**KIRKLEES METROPOLITAN COUNCIL
INVESTMENT & REGENERATION SERVICE**

Reference No:	2024/62/91347/W
Site Address:	15, Colwyn Street, Marsh, Huddersfield, HD1 4PF
Description:	Erection of single storey side and rear extensions with front and rear dormers
Recommending Officer:	Laura Yeadon

Officer Report

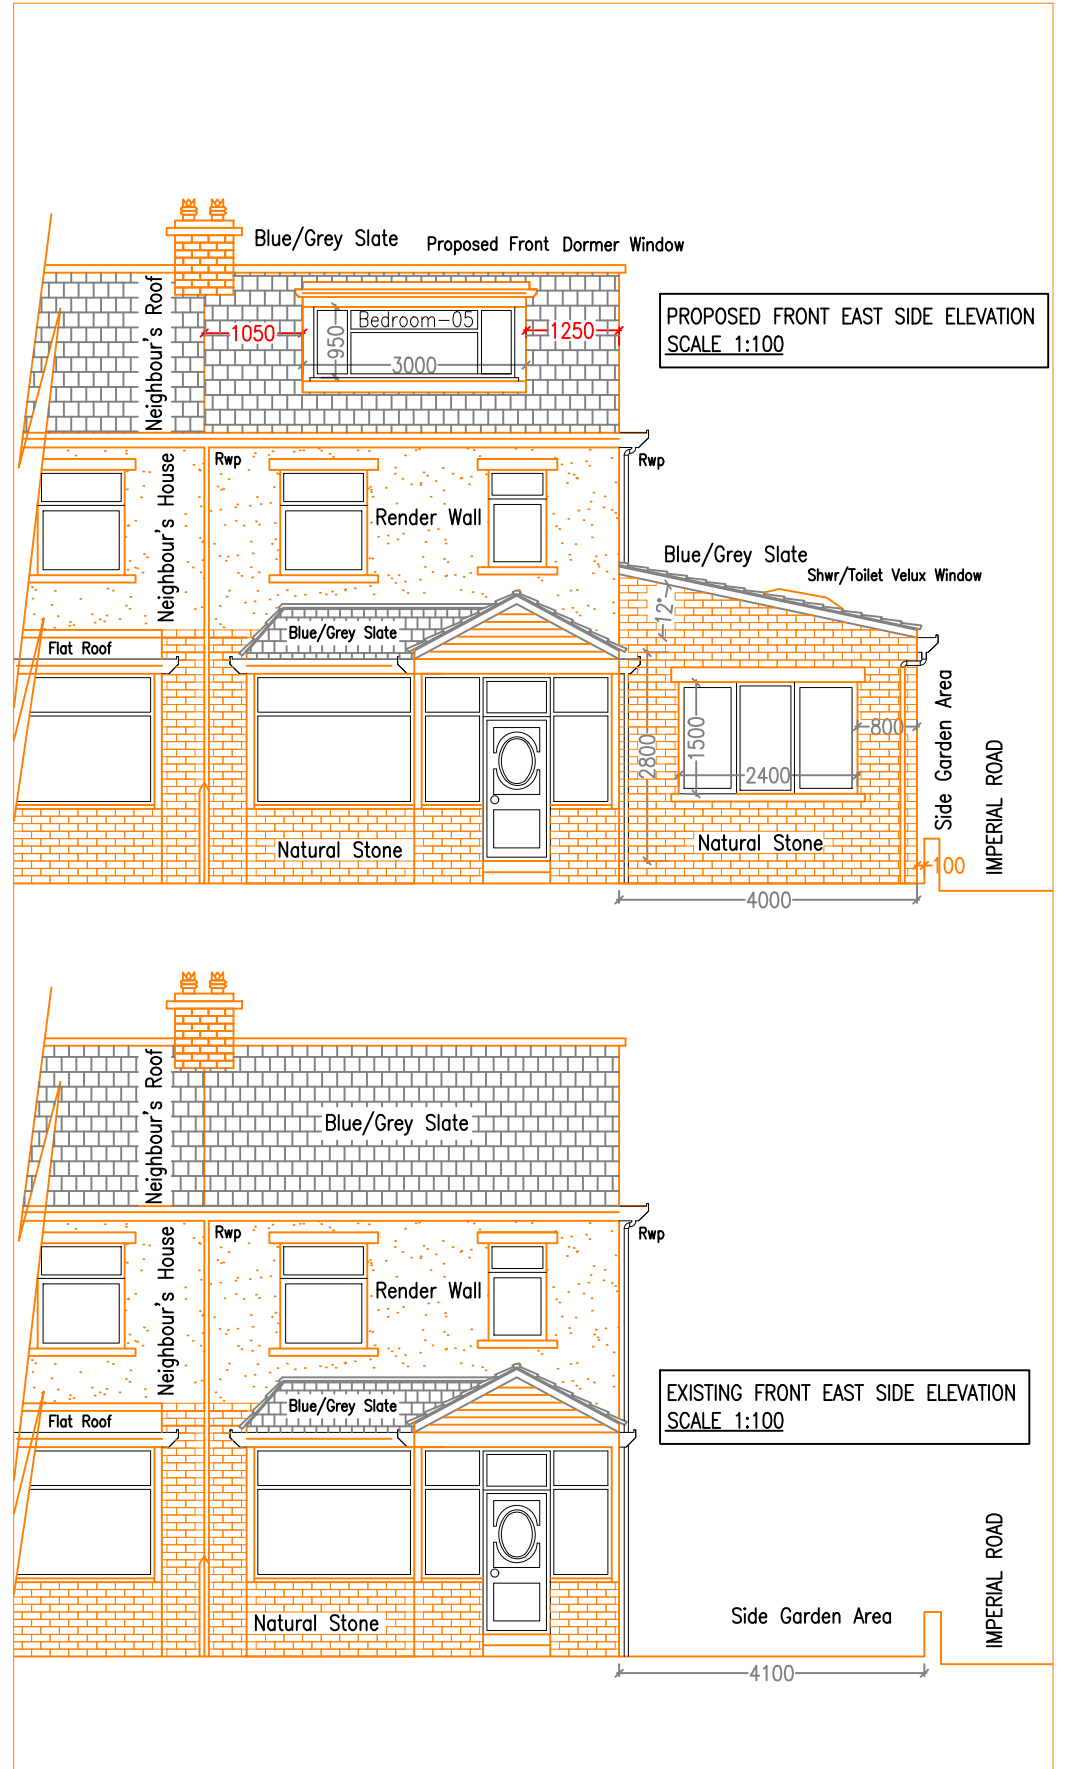
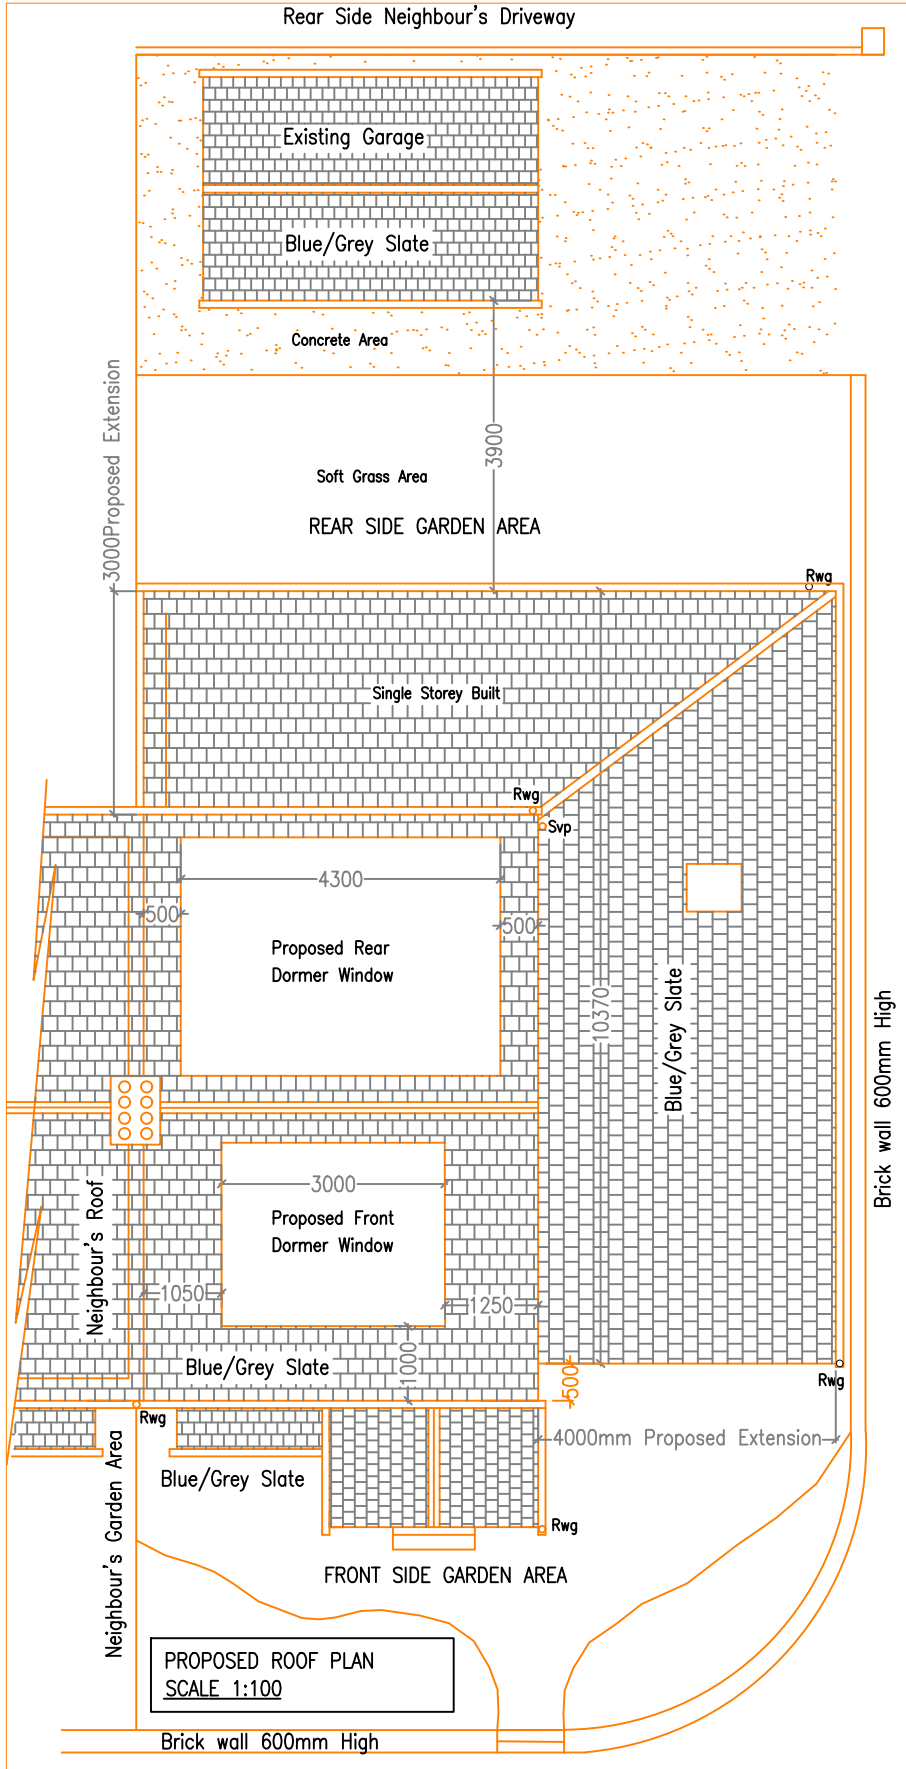
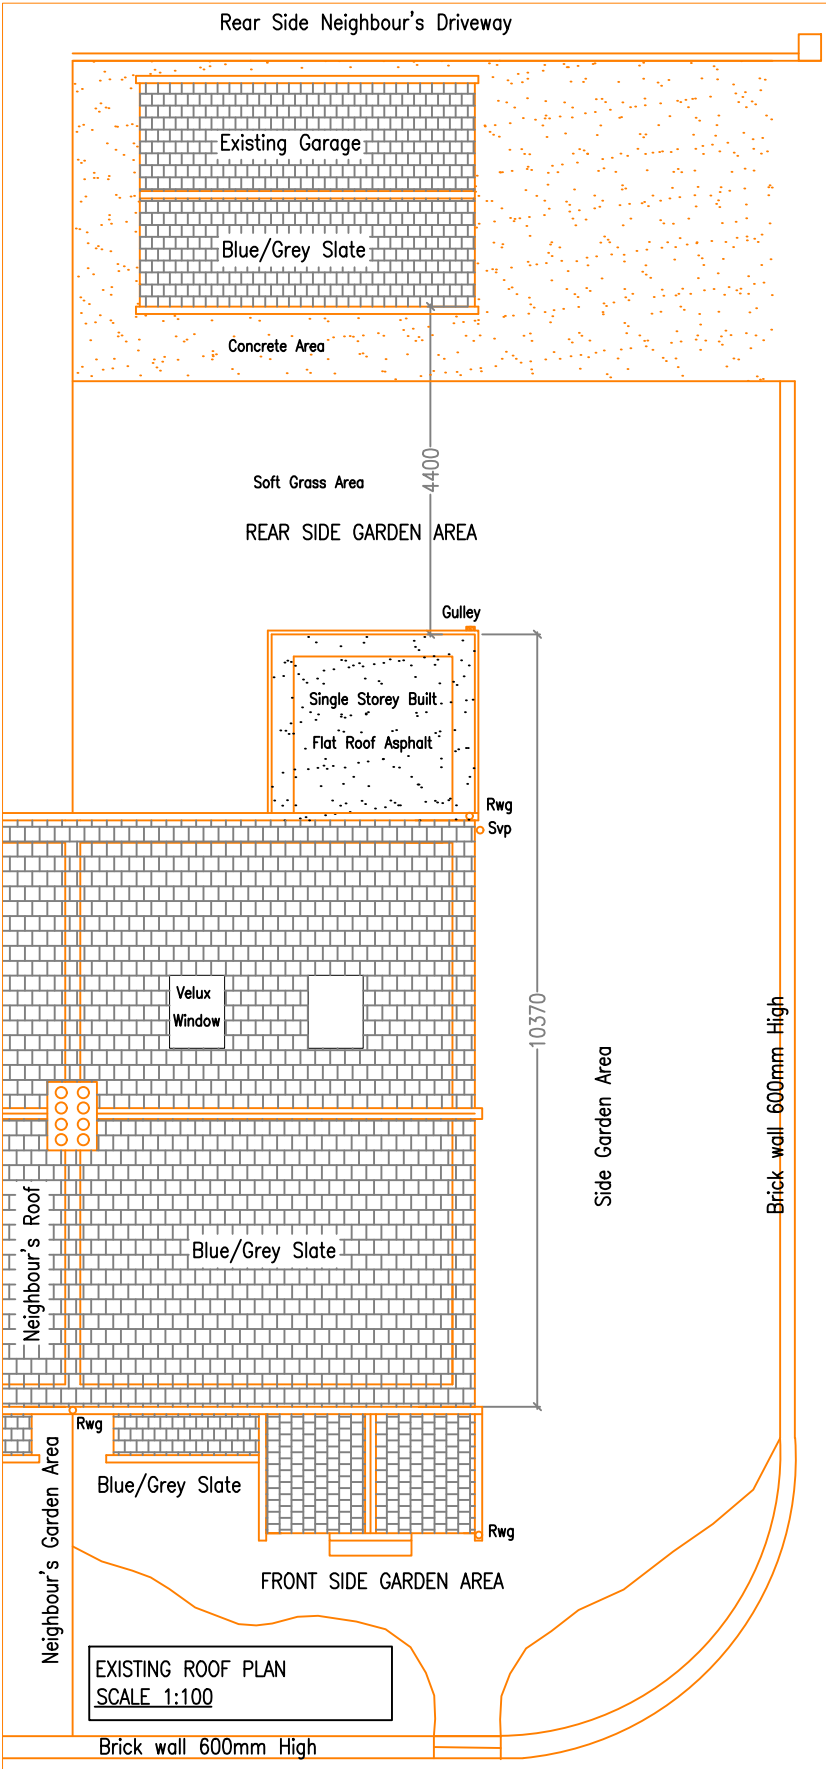
The proposed dormer to the front of the property would be set up from the gutter line by 0.5 metres and set down from the roof ridge by 0.3 metres. The total width of the dormer would be 3 metres and would be set in from the side elevation and the shared boundary of the property.

The proposed rear dormer extension would be larger than the front dormer being set up from the gutter line by 0.2 metres and set down from the roof ridge by 0.3 metres. The total width of the dormer would be 4.3 metres and would be set in from the side elevation and the shared boundary of the property.

The proposed dormer extensions would be located on the front and rear elevations of the property. The dormers would not dominate the roof or project above the ridge of the property, would be set below the ridgeline and within the roof plane with acceptable siting of the openings. The dormers are of a sufficient dimension to retain the original roof form to be clearly read and therefore, in terms of visual amenity, are considered to be acceptable.

3. The external walls and roofing materials of the extension hereby approved shall in all respects match those used in the construction of the existing building. The external materials used in the construction of the walls of the dormers hereby approved shall either be finished in dark grey colour finish or be tiles / slates which, in all respects, match those used in the construction of the existing building.

PROPOSED SOUTH SIDE ELEVATION
SCALE 1:100

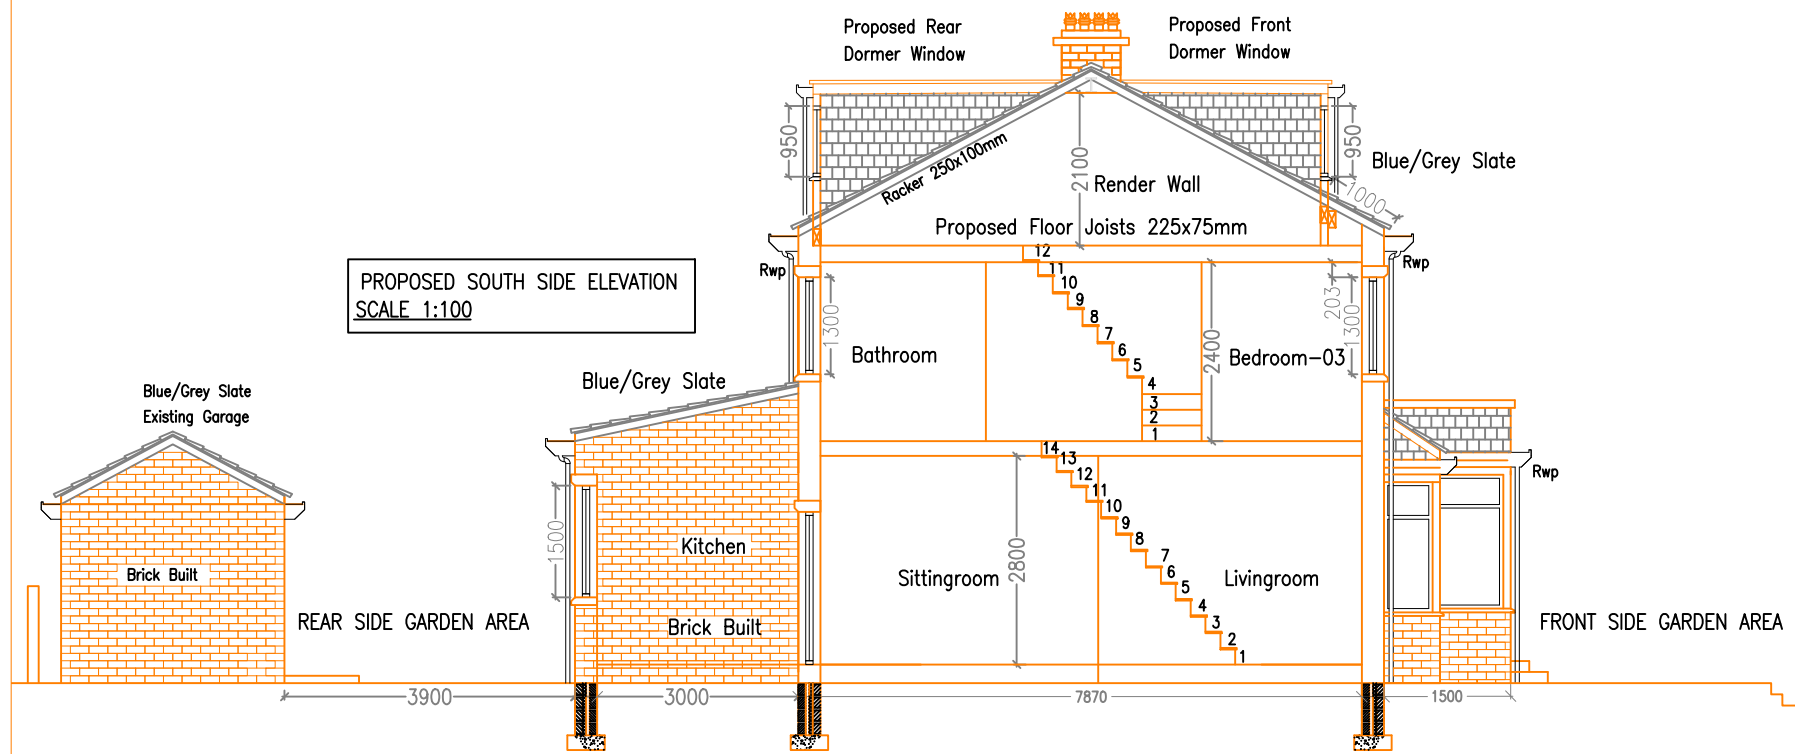
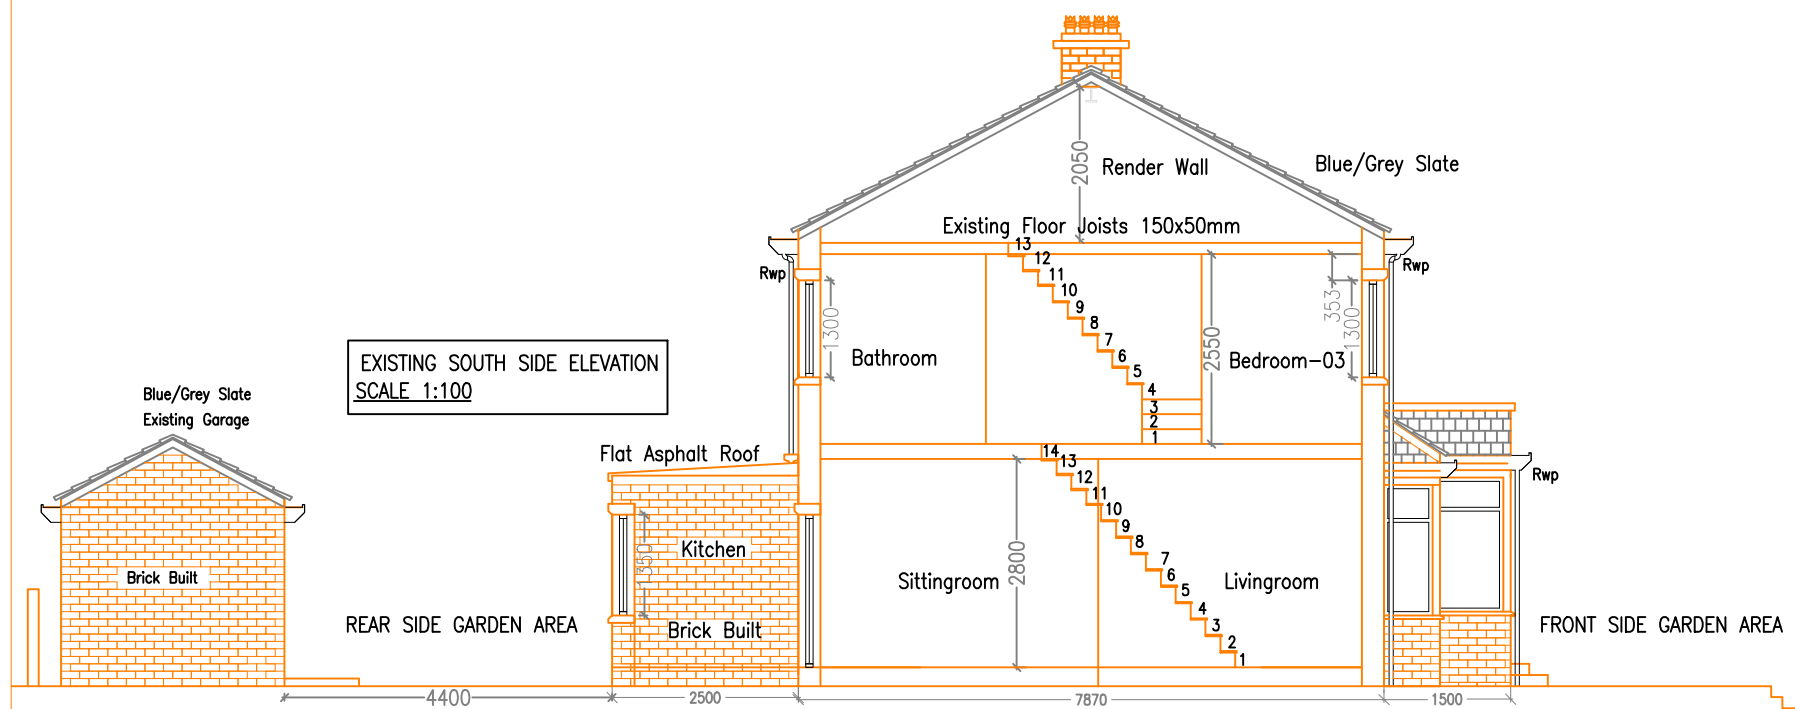
The property is sited within a corner plot and therefore, paragraph 5.23 of the SPD is of relevance. As the proposed side extension would span the width of the plot abutting the boundary with the roadside, concerns were raised with regard to the loss of a sense of space around the building and it was requested that the extension be set in from the side boundary. In response, the applicant has referred to another property within the locality with a similar arrangement to that propose in this case, which obtained planning permission. In addition it is noted the planning history of the site (ref: 2016/90661) would allow for a similar size / scale of development to be completed to the side given this consent was part implemented. In this case there is considered to be sufficient justification present, as required by the house Extensions and Alterations SPD, in relation to this element of the scheme.

Whilst two frontages would not be created, given the proximity of the works to the public highway, this is a similar situation as that previously permitted, and which can be lawfully completed, therefore the absence of creating a frontage within the side elevation of the building is considered to be acceptable in this case.
